**1st REVIEW – DEVELOPMENT PLAN – APPROVED WITH CORRECTIONS
CIMARRON HILLS FIRE PROTECTION DISTRICT (CH2017-35-DP-1)**

August 2, 2017

FILE NUMBER: PPR-17-031

The Cimarron Hills Fire Department submitted an electronic development plan to PEAK Consulting Services, Inc. for a fire code compliance review of a proposed commercial building for the **NEW CRACKERJACK MUD JACKING BUILDING** located at **7315 McClain Point** within the Cimarron Hills Fire Protection District. This scope of work includes: **A new 3,750 square foot single story industrial building.**

JOB NUMBER	696-17
REVISIONS	
8-26-17	PER COUNTY COMMENTS
ORIGINAL DATE	6-28-17
DRAWN BY:	JM
DESCRIPTION:	LANDSCAPE PLAN
SHEET NO.	LP-01
	PPR-17-031

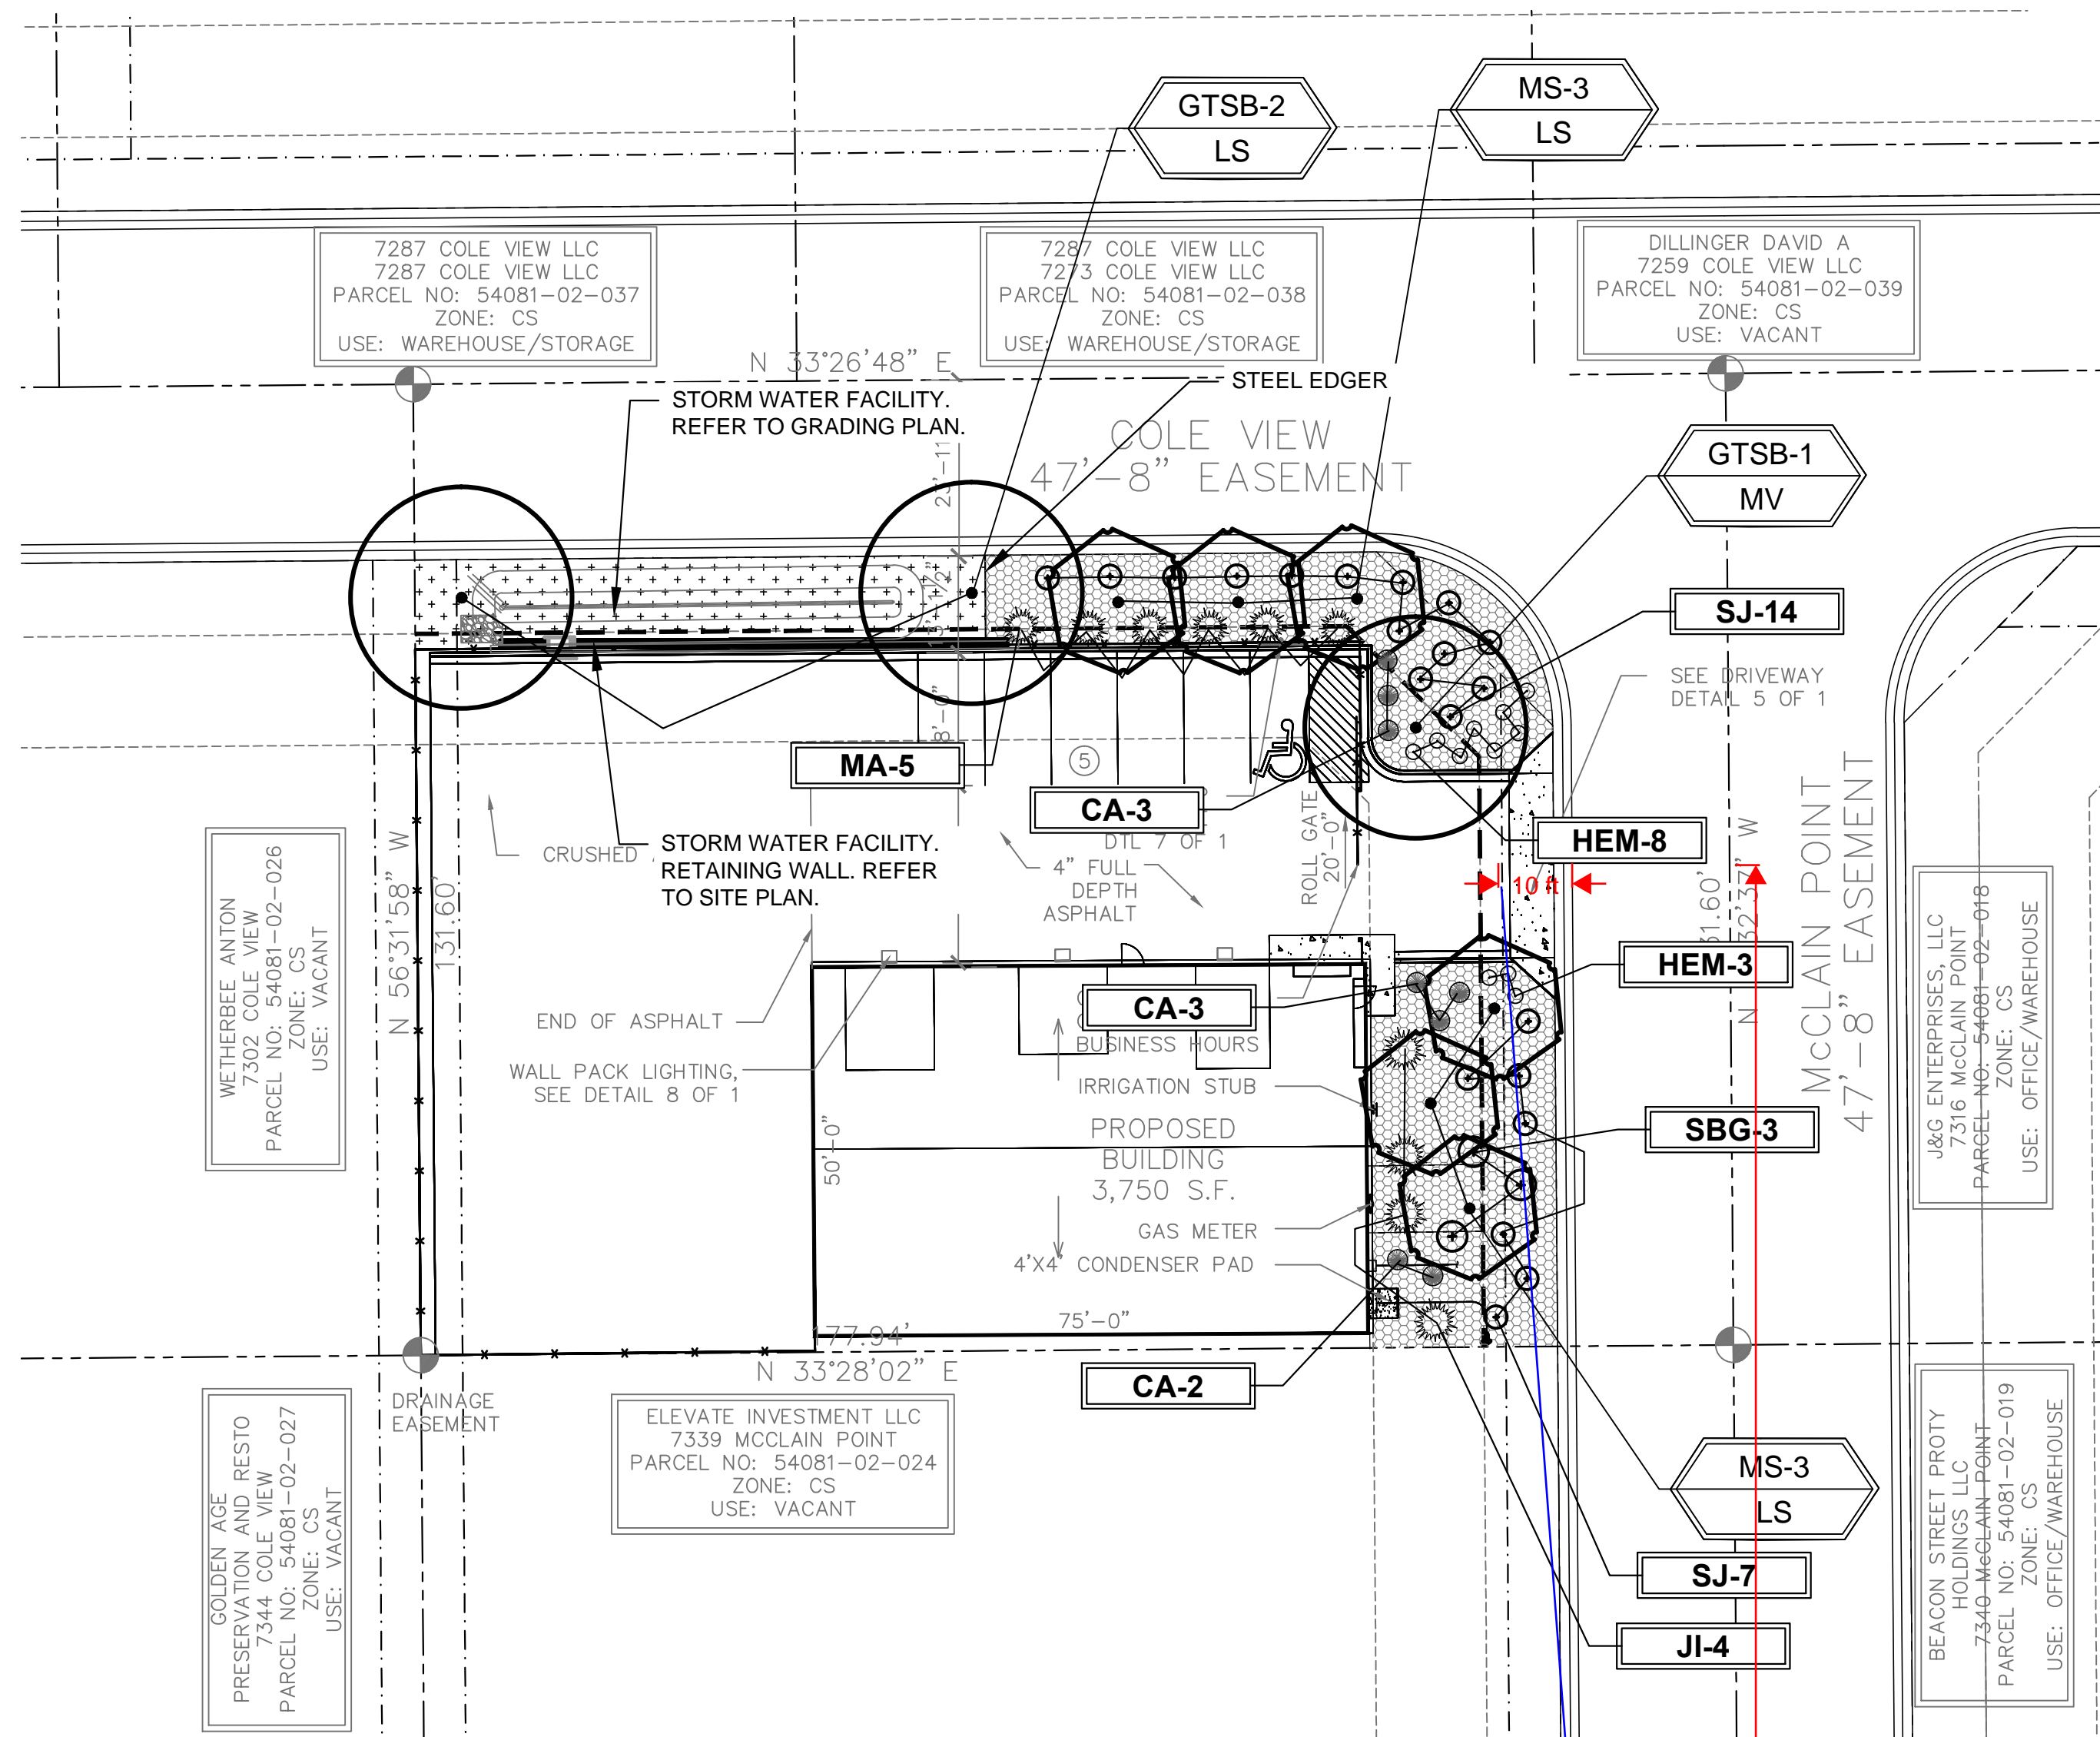
TURNING RADIUS – The East End of this development indicates that there will be RV parking. NOTE: Turning Radius requirements shall be maintained and not impeded upon parked RV's.
